Memorandum
Planning and Urban Development Department
Planning Division

Date: February 23, 2018

Re: MMC East Tower and Visitor Garage Vertical Expansion
 22 Bramhall Street
 Maine Medical Center (MMC)

Project #: 2017-289 CBL: 053D007/054H001/064C001

CONSTRUCTION ACCESS GATE

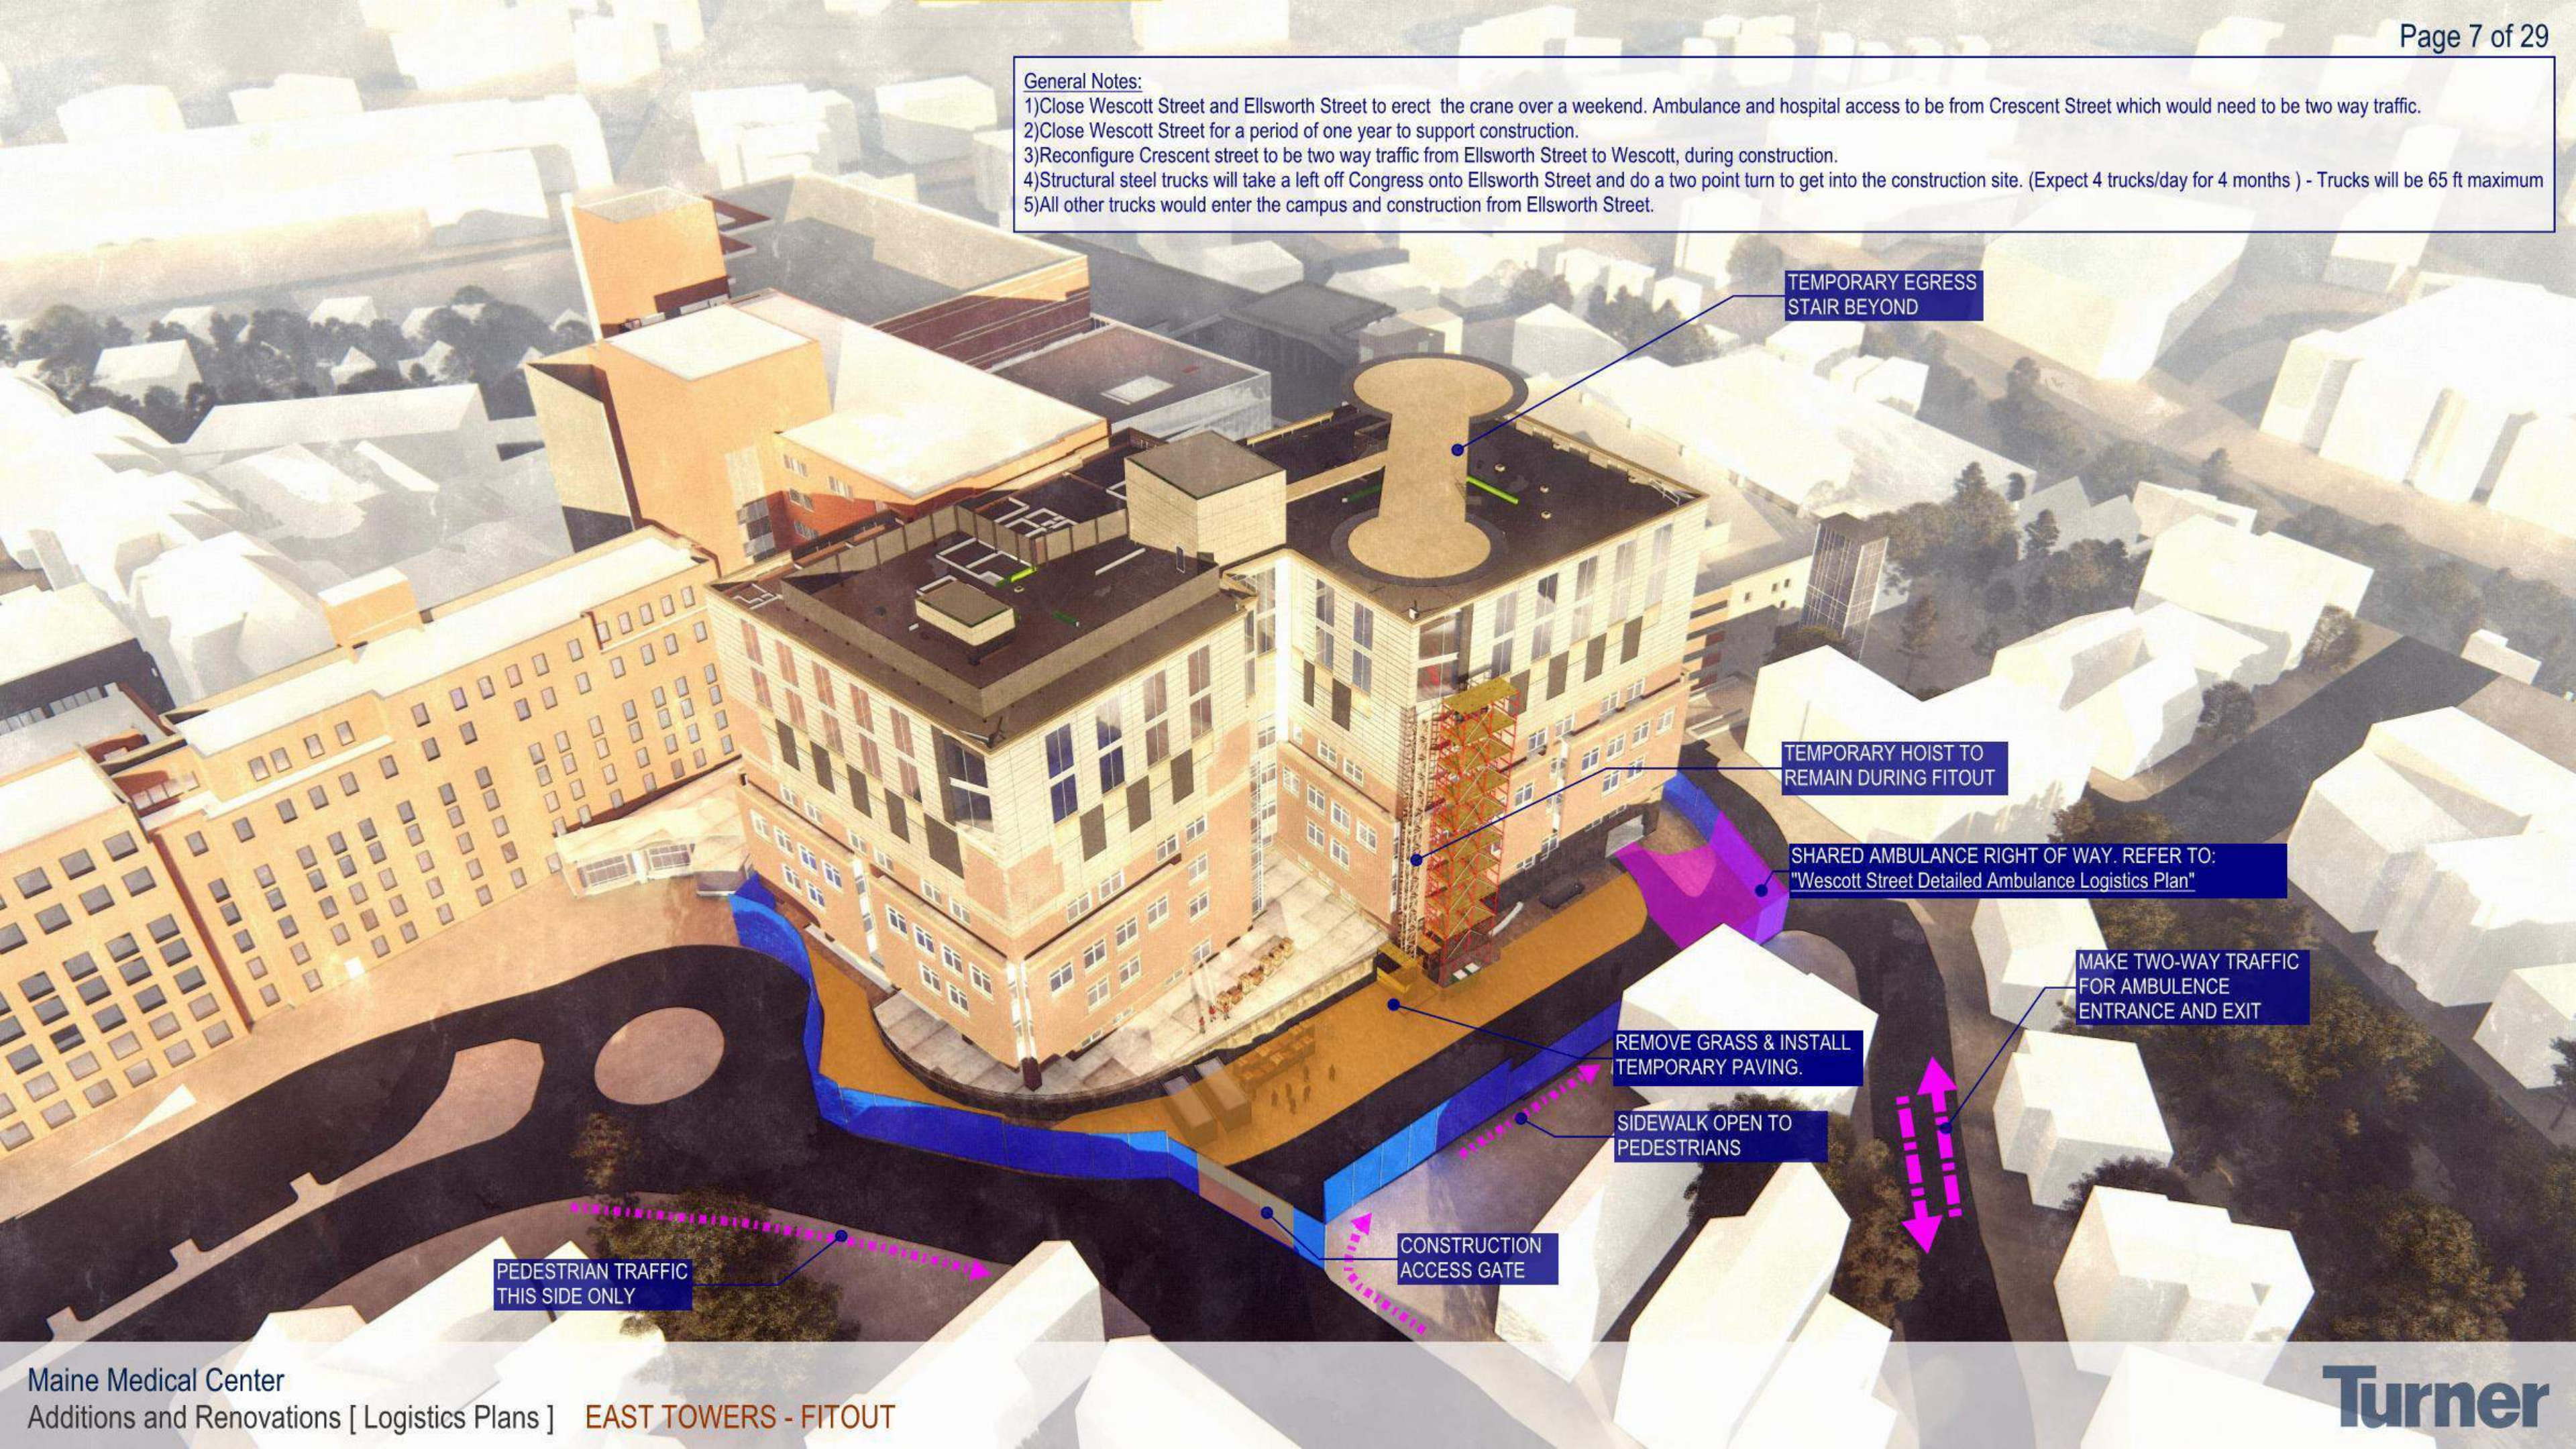
Since the first PB Workshop MMC and Turner has submitted a revised CMP (Second Workshop Plan WSI-5 CM Plan) that has been revised as follows:

- Access for ambulances has been revised to remain as existing by relocating the site fencing and modifying the curb to provide ambulance access to the bays under East Tower
- References to converting Ellsworth to two way have been removed
- Precast and steel delivery routes added
- Location of concrete washout areas added per Wright Pierce Peer Engineer comments (Att. 9, 1.25.18)

**MMC HOSPITAL EXPANSION  
 EAST TOWER OVERBUILD  
 STRUCTURAL STEEL  
 TRUCK ROUTE FROM I-295N TO MMC SITE ON  
 WESCOTT STREET  
 1-295 N TO WASHINGTON AVE. TO CONGRESS  
 STREET TO ELLSWORTH STREET TO  
 WESCOTT STREET SITE**

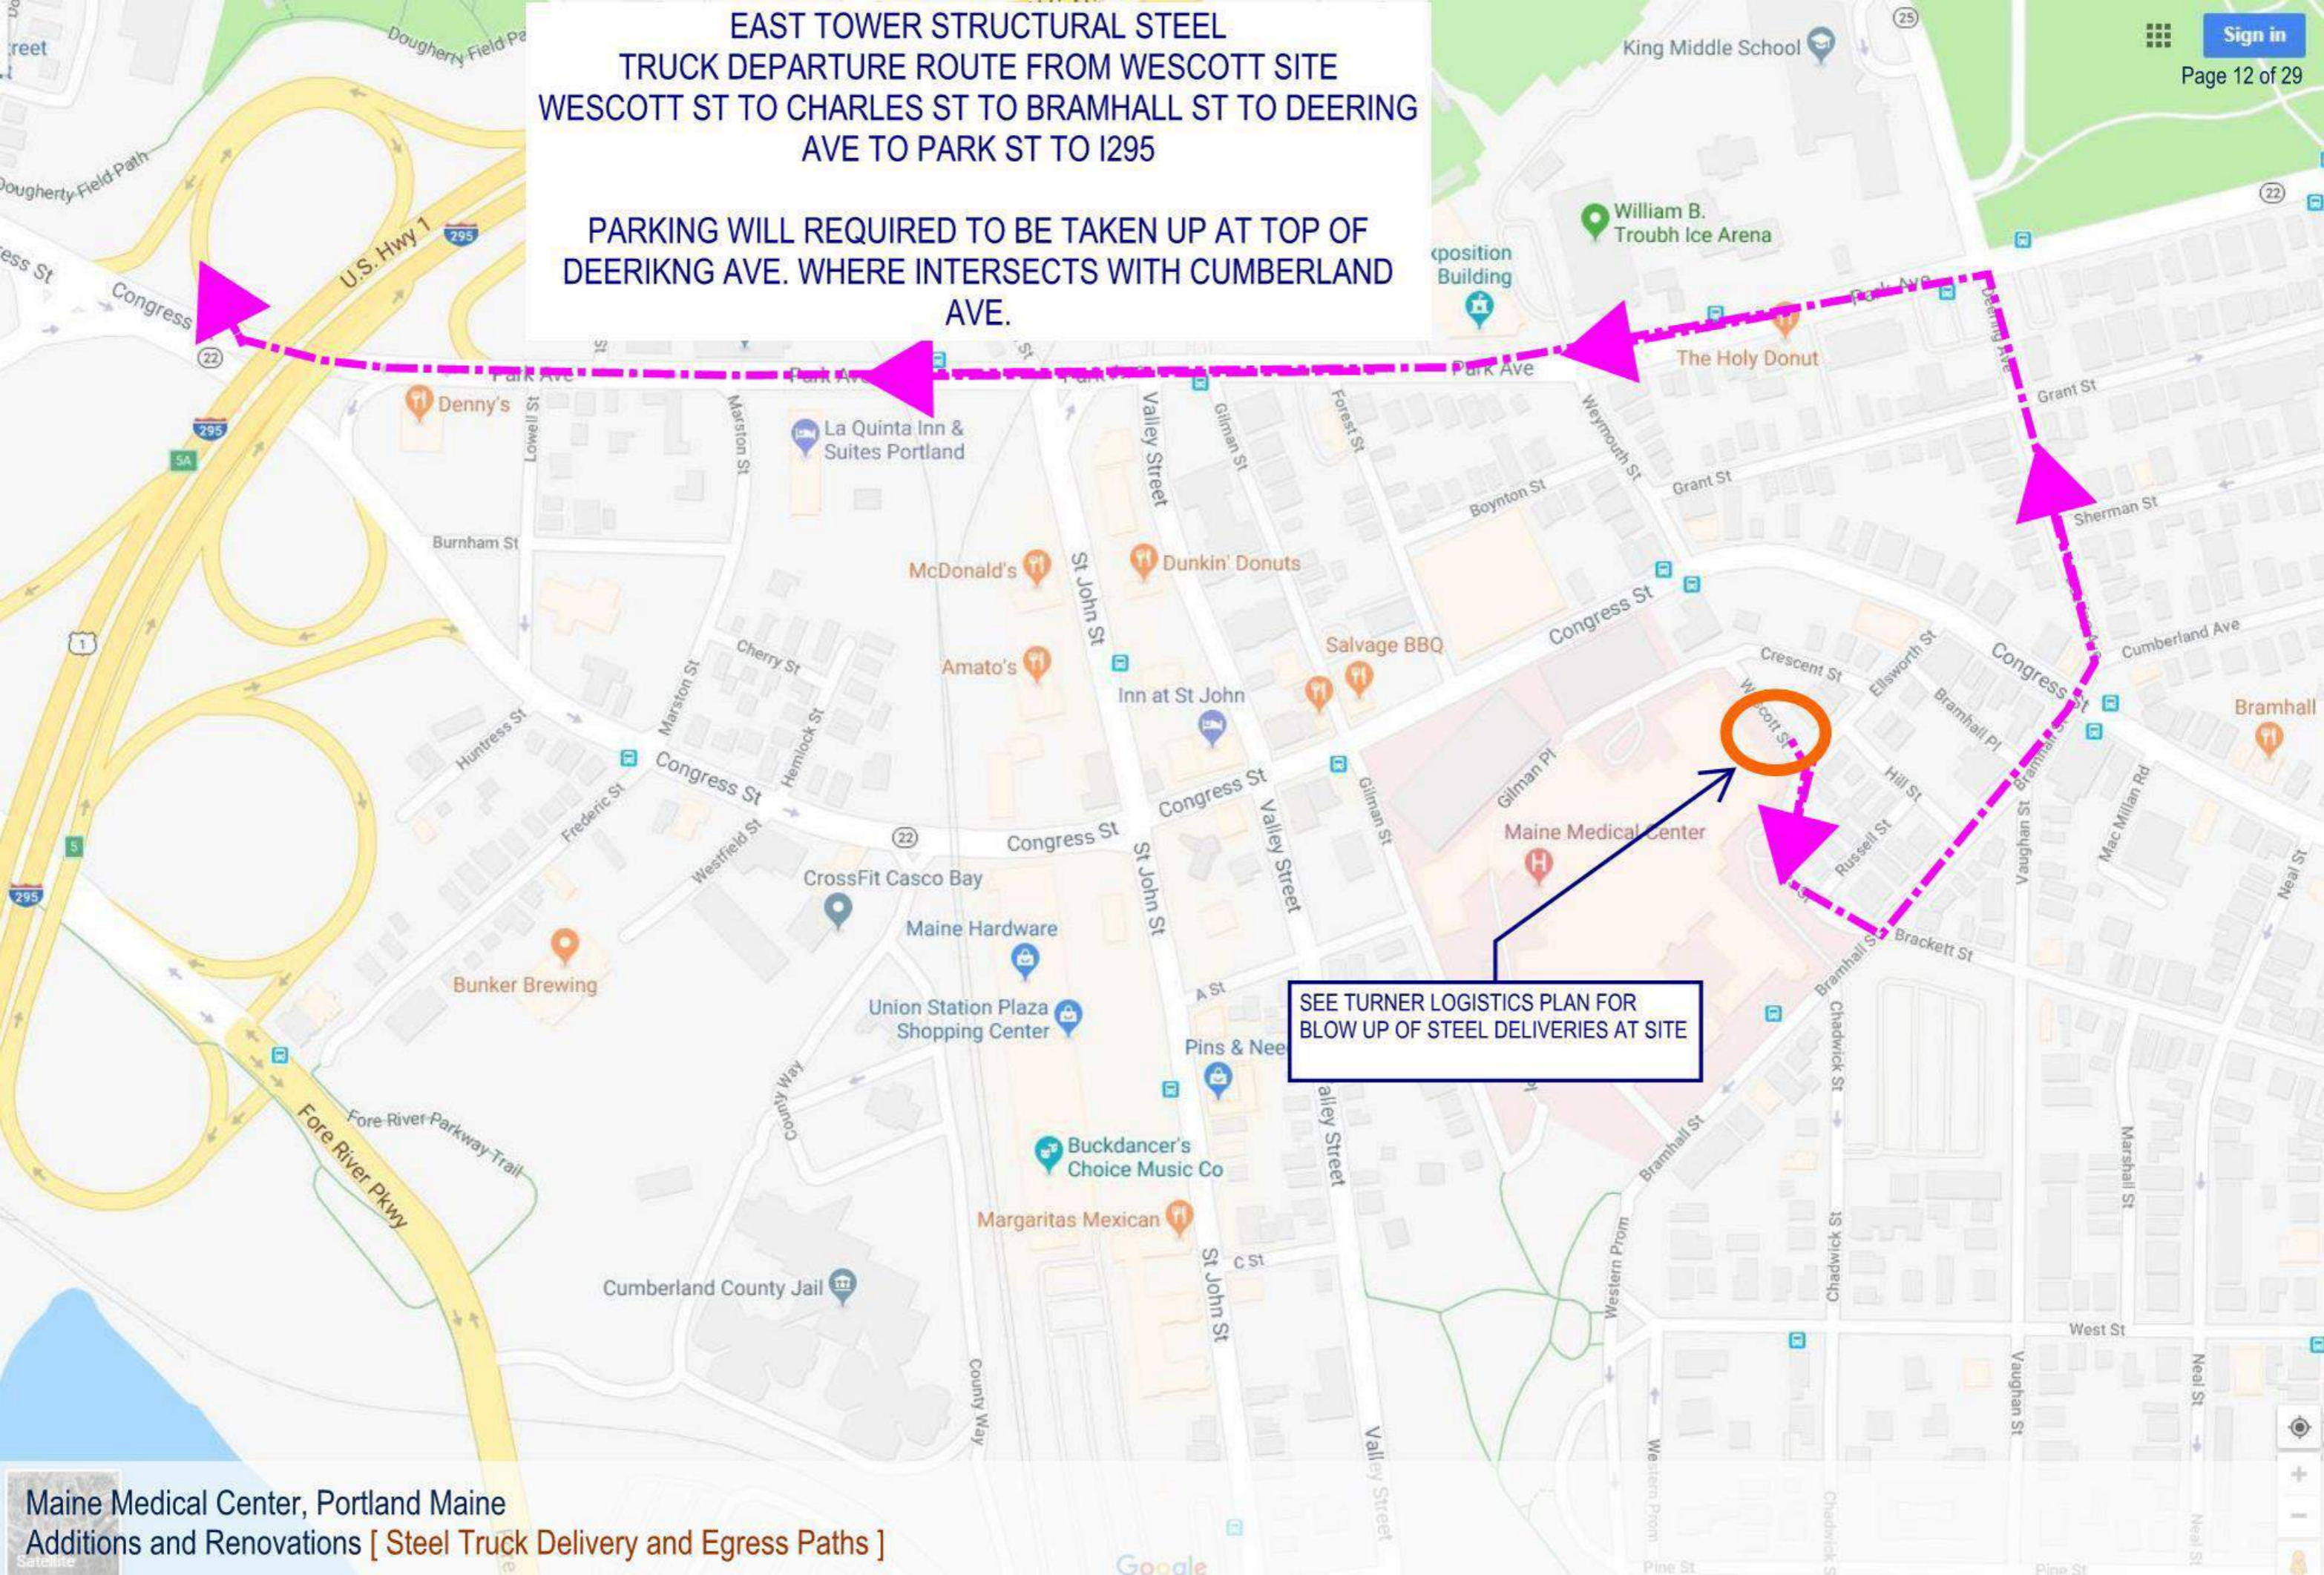
- The feasibility of the pedestrian route alongside the crane in Congress Street (the crane at right is the type of crane that will be needed)
- The delivery route for the steel for the East Tower is proposed to go via Washington Avenue and Congress Street
- Delivery hours to avoid peak traffic times
- Enforcement of contractor employee parking not to be on local streets
- Introduction of penalties and other measures to ensure the closure is reopened prior the July 4th holiday weekend.
